Our Case Number: ABP-316272-23

Re: Bus Connects Templeogue/Rathfarnham to City Centre Core Bus Corridor Scheme
Templeogue/Rathfarnham to City Centre

ABP case ref: 316272

BUSCONNECTS TEMPLEOGUE/RATHFARNHAM CORE BUS CORRIDOR SCHEME

Drawing File Name: BCIDC-ARP-GEO_GA-1012_XX_00-DR-CR-0018 | Sheet Number: 18 of 42 | Status: A | Rev: M01

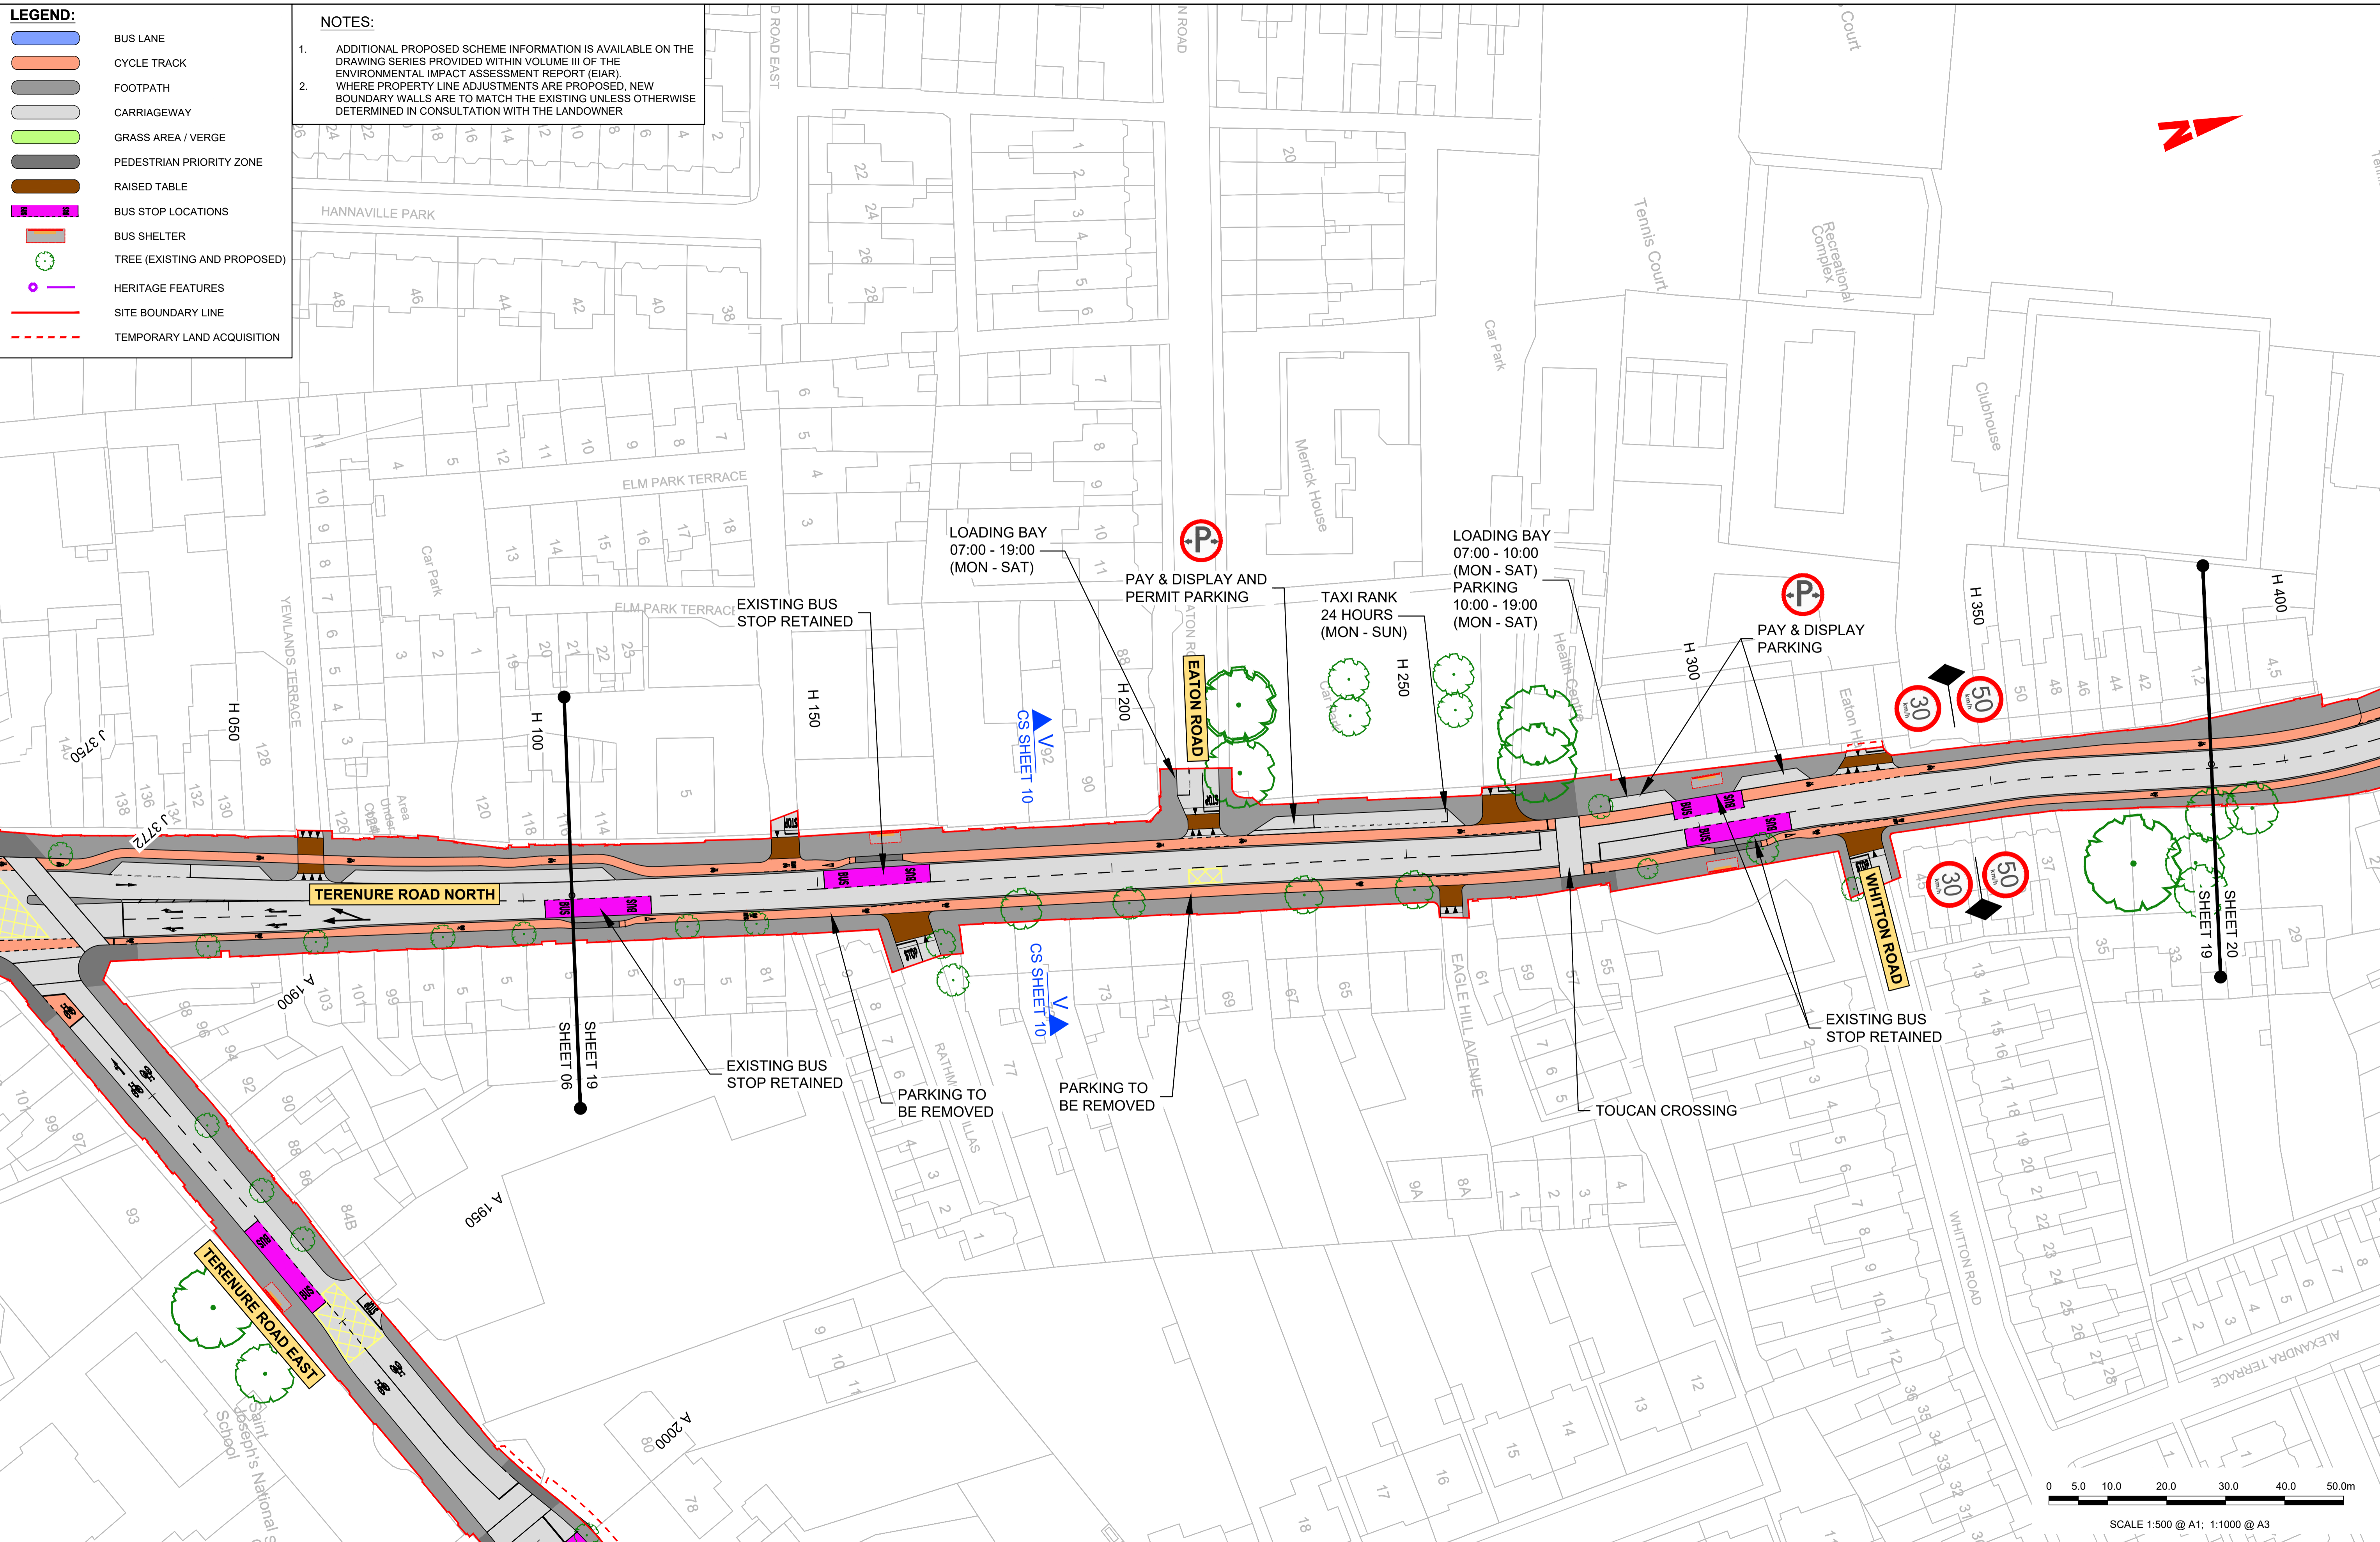
The placement of the bus shelter on South Great George's Street (sheet 18/42) does not align with the pedestrian island to disembark from the bus. There is a possibility that pedestrians might walk through the cycle track, rather than up and around the traffic island where cyclists are likely to be waiting, increasing the chances of a conflict. We would recommend making adjustments to the plans to align the bus stop with the traffic island to avoid this potential conflict point between cyclists and pedestrians.
